From: Jeff Smith <Jeffrey.Smith@endeavourenergy.com.au>
Sent: Thursday, 8 July 2021 9:30 AM
To: Grant Harlow
Subject: RE: S29/3/97-Mod-1 - Eastern Creek Karts, Departments design comments

Subject: S29/3/97-Mod-1 - Eastern Creek Karts, Departments design comments

Following on from our discussions on design requirements on 26th and 28th May 2021 for the above please see the following notes for design work :-

TITLE:
BIO-RETENTION

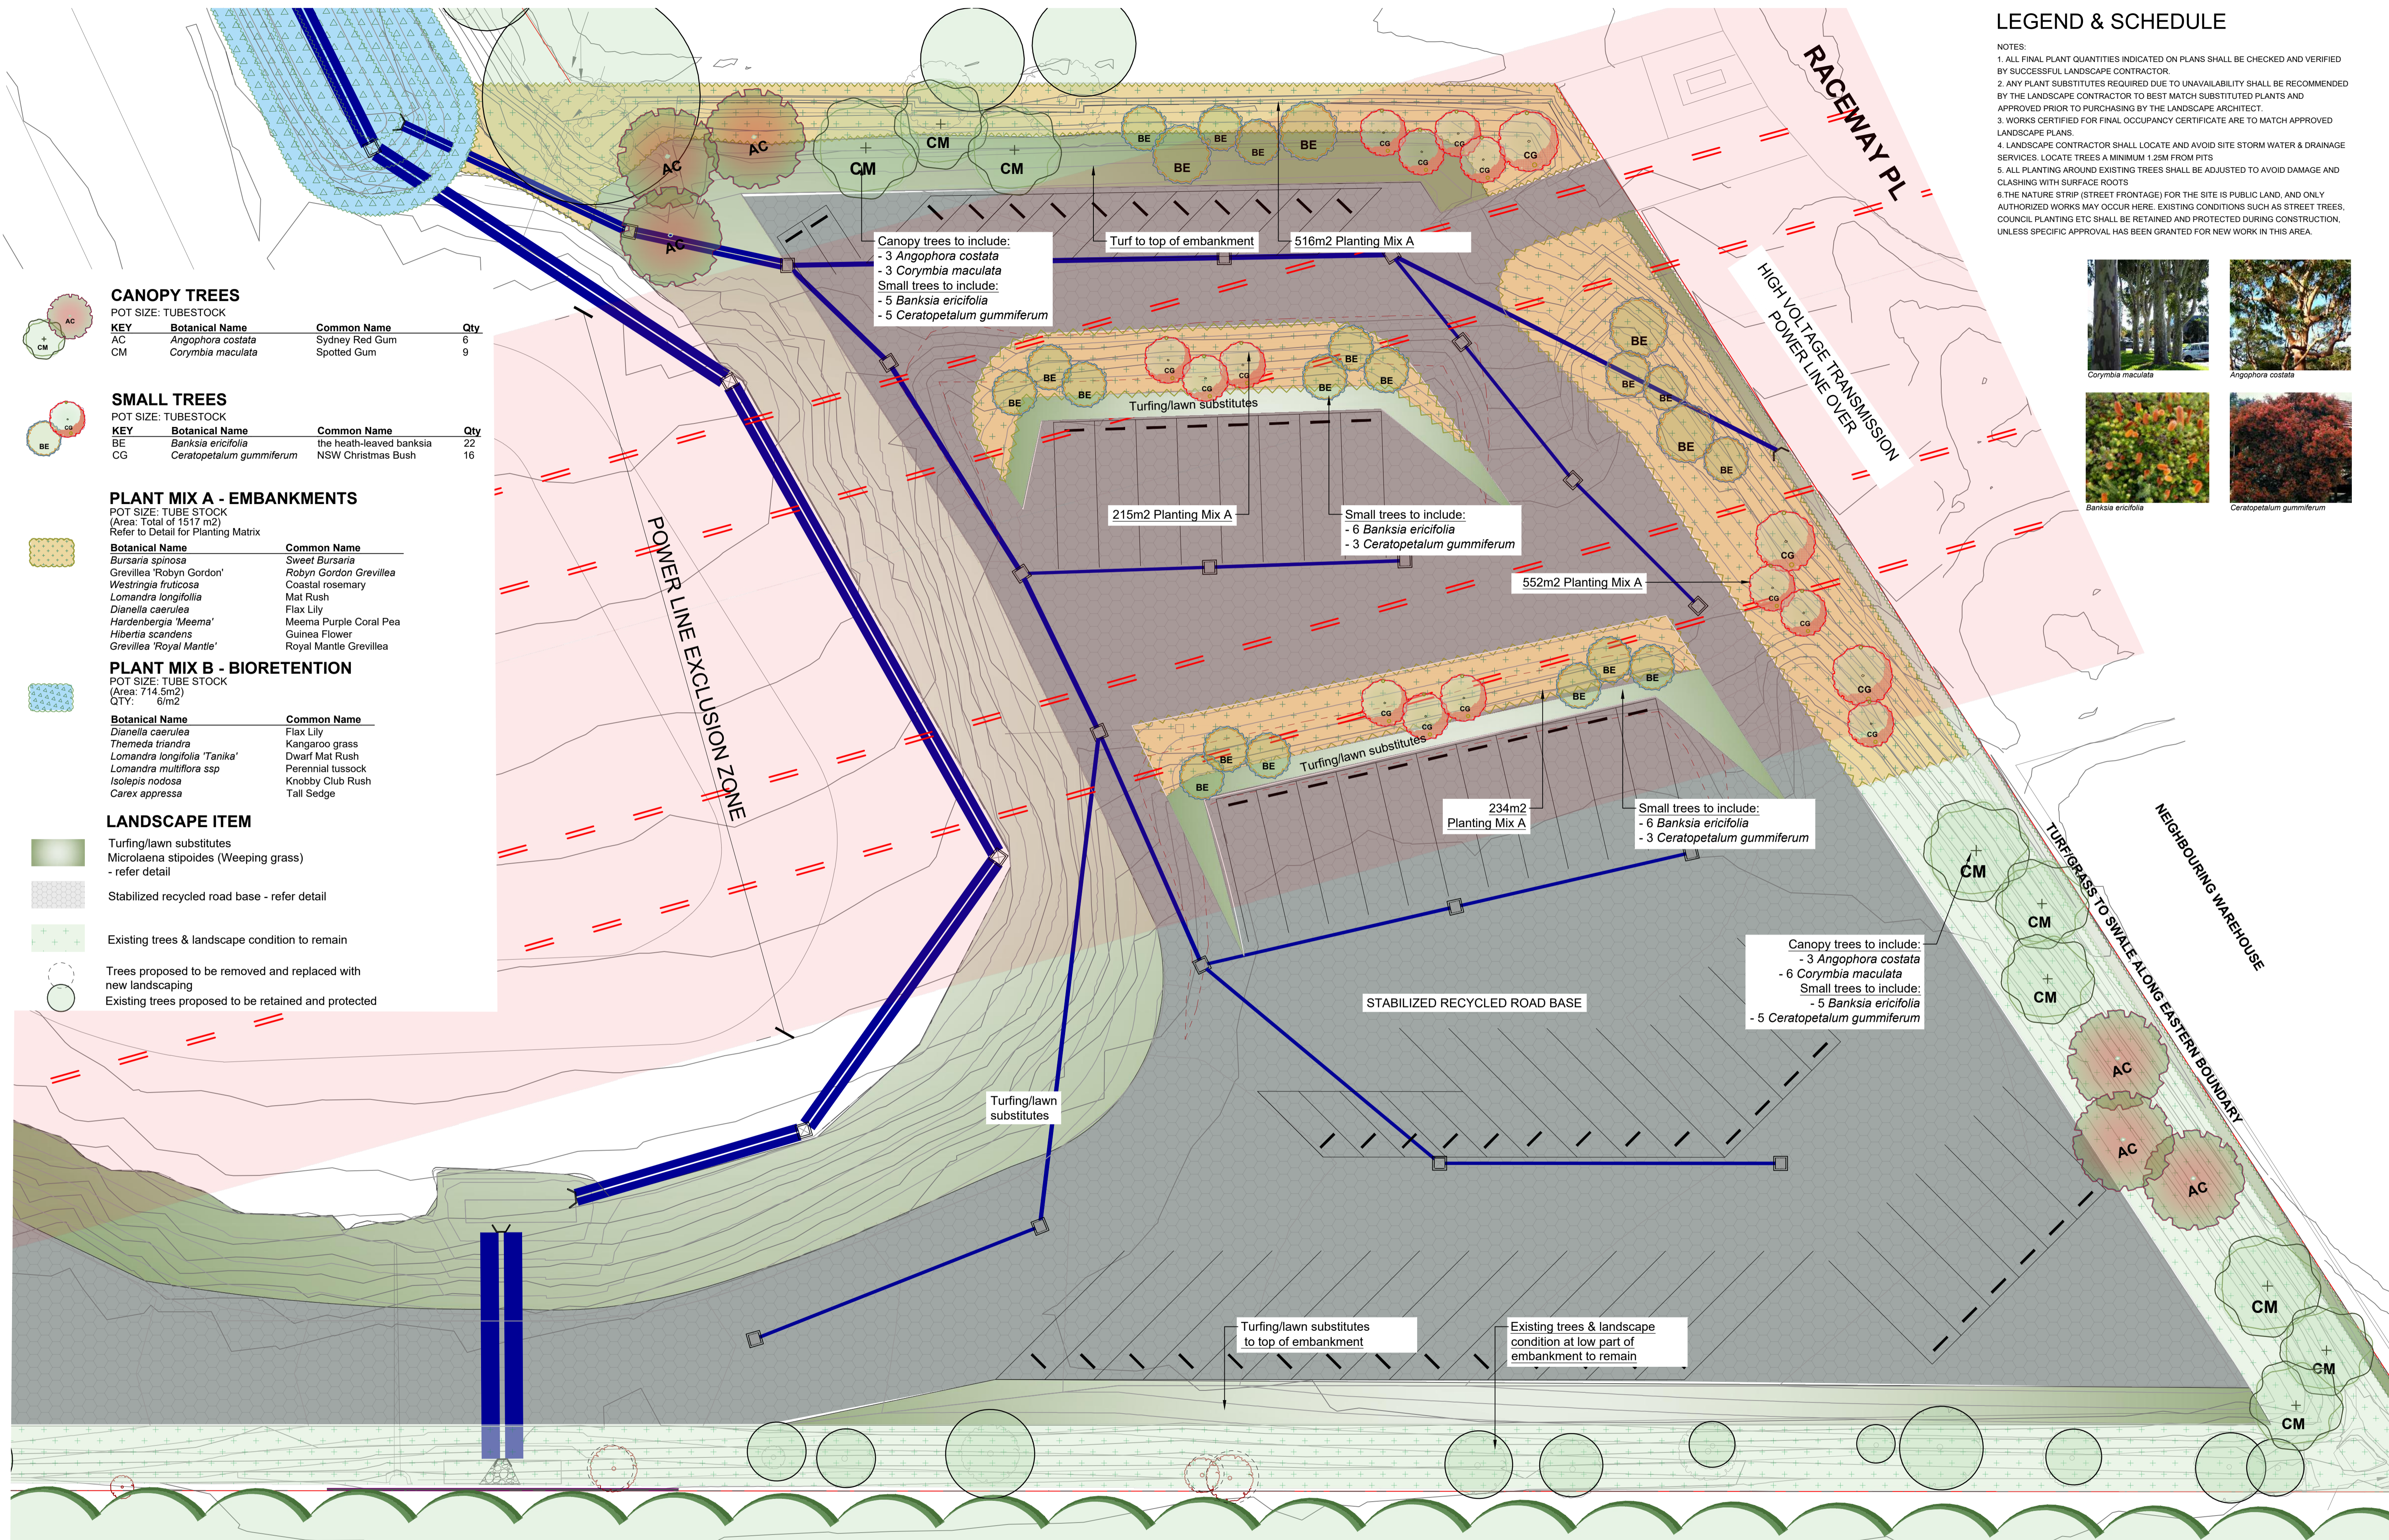
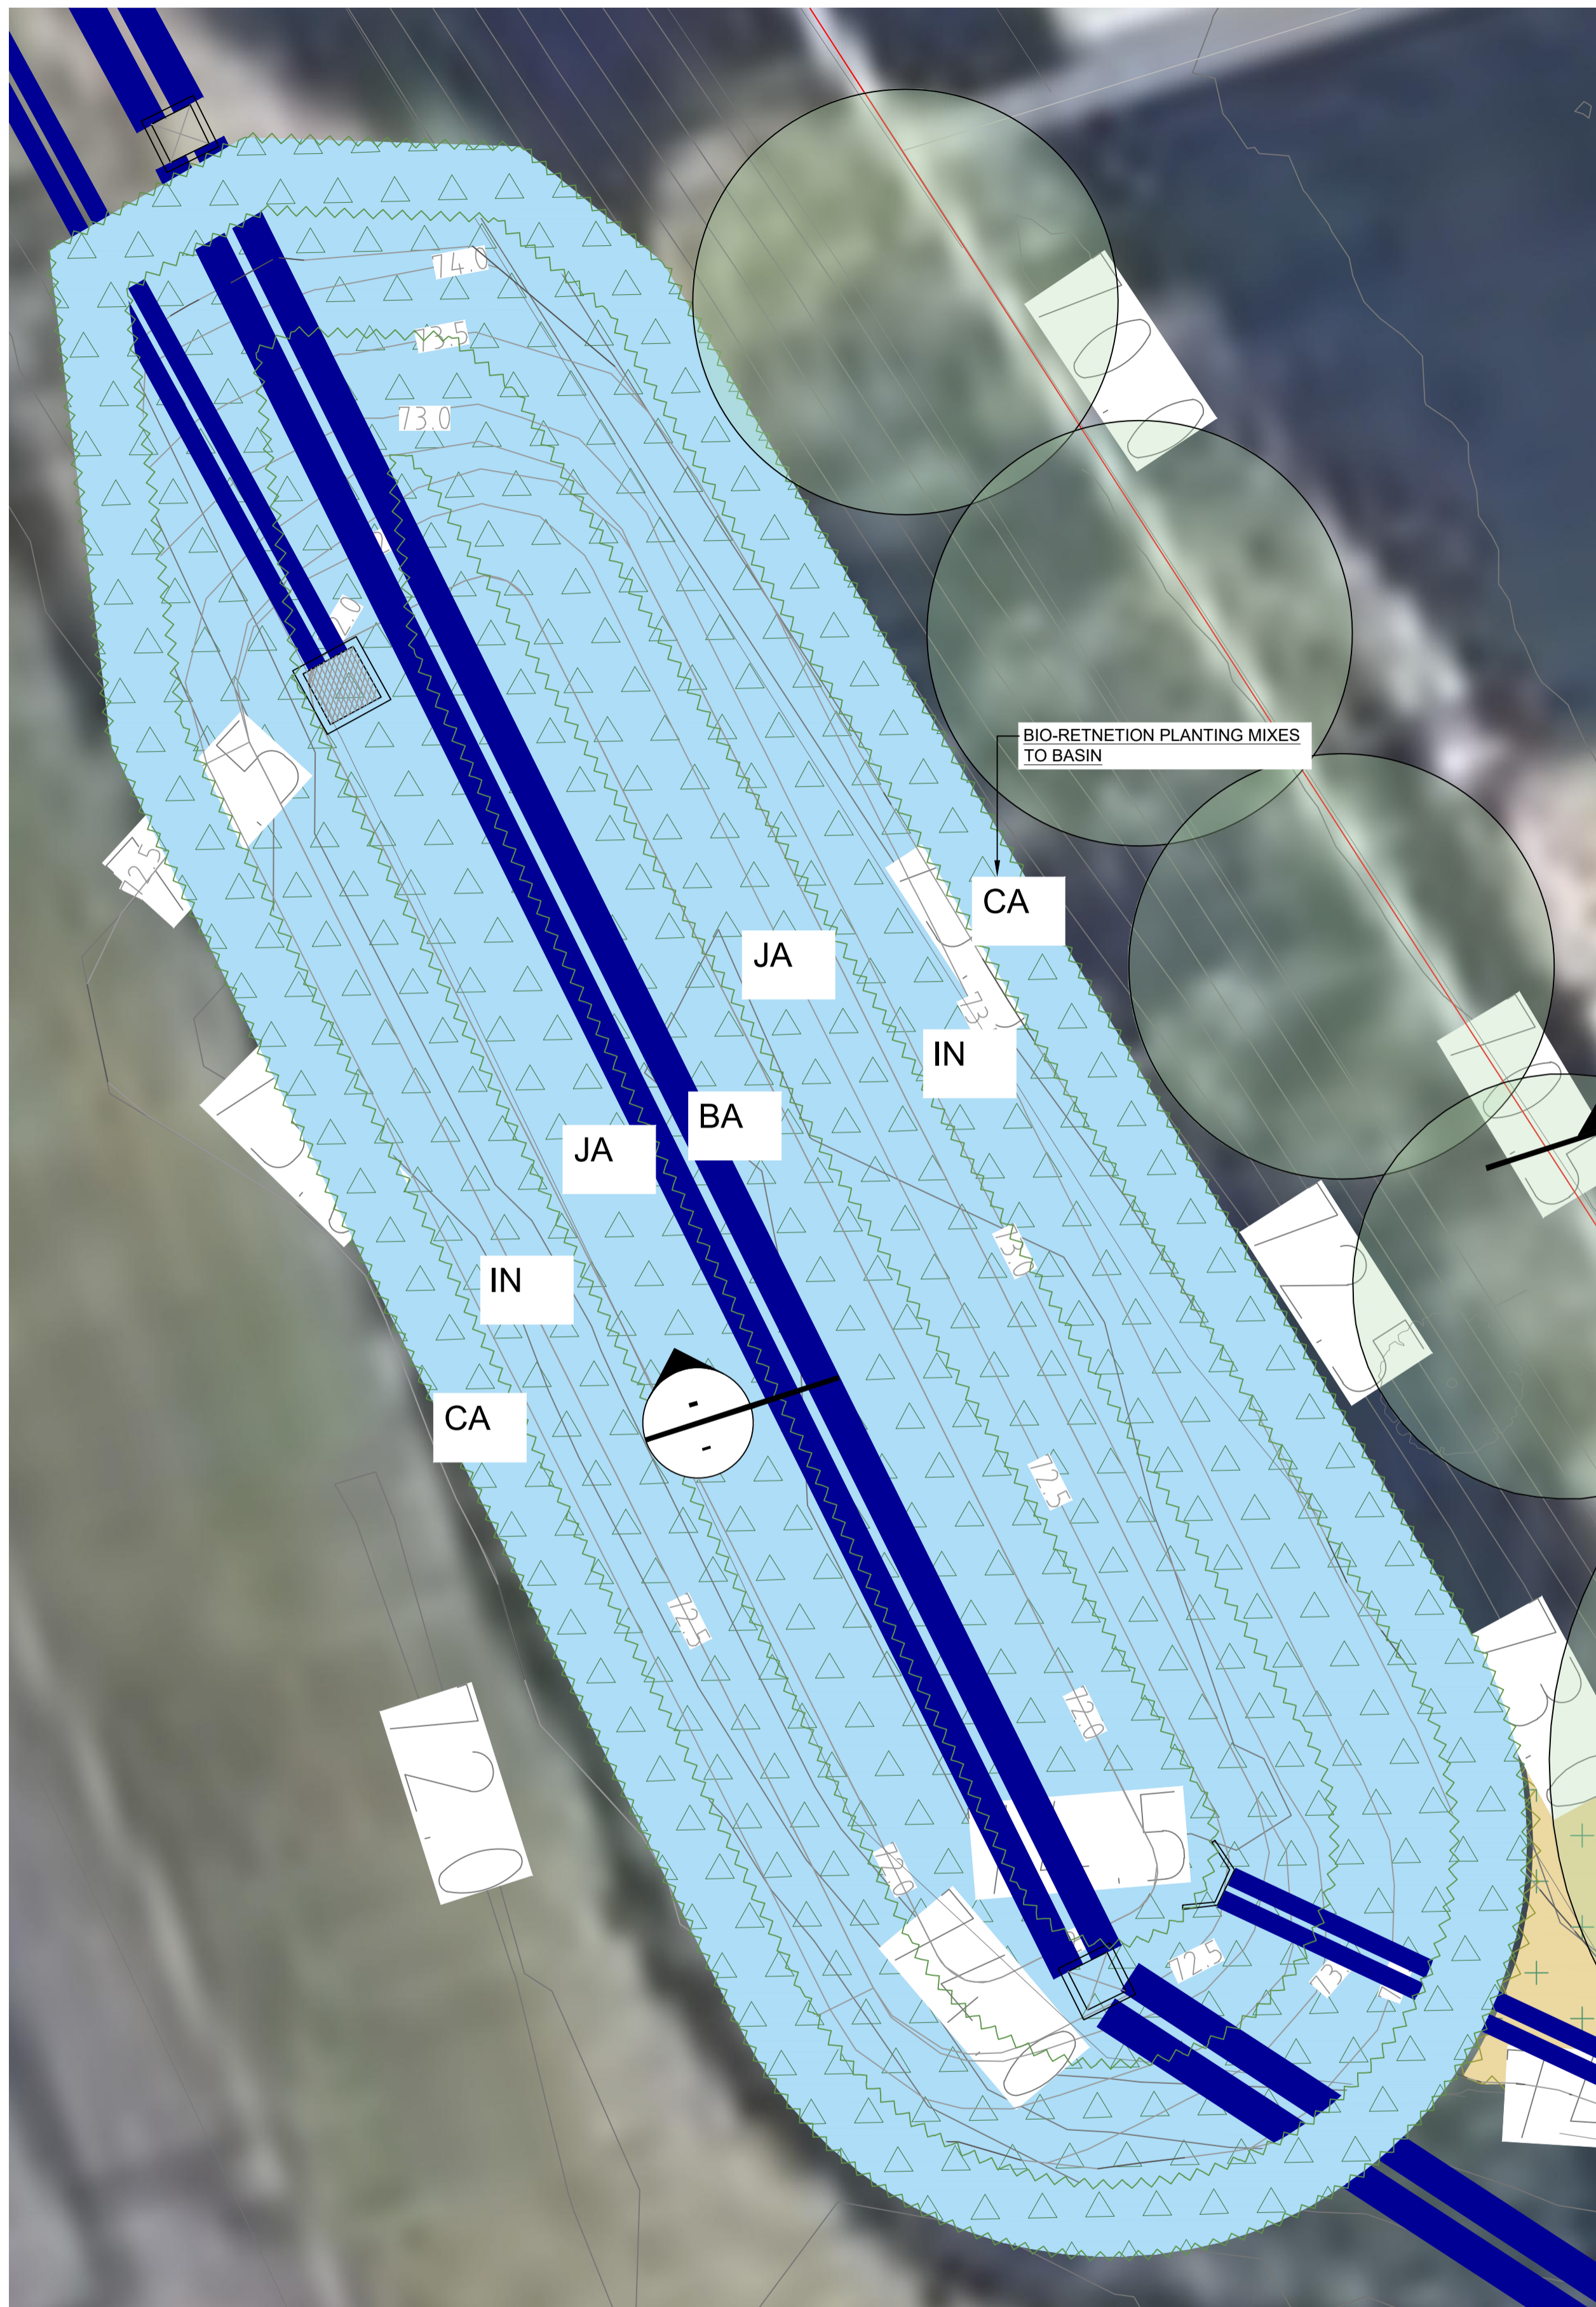
6. The culvert is generally sized for at least the 100 yr ARI after applying design blockage, and sized for the PMF after blockage would be desirable.
7. The southern boundary and eastern boundary swales should be designed for at least the 100 yr ARI. Grassed swales are an option however it depends how they perform with design flowrates. Concrete lined swales can reduce roughness. Provide a statement on impacts of this design on existing trees.

11. The landscape professional may consider locating trees, if they assist in reducing visual impacts, away from paving, safety devices and batters. Please provide more detailed landscape plans.
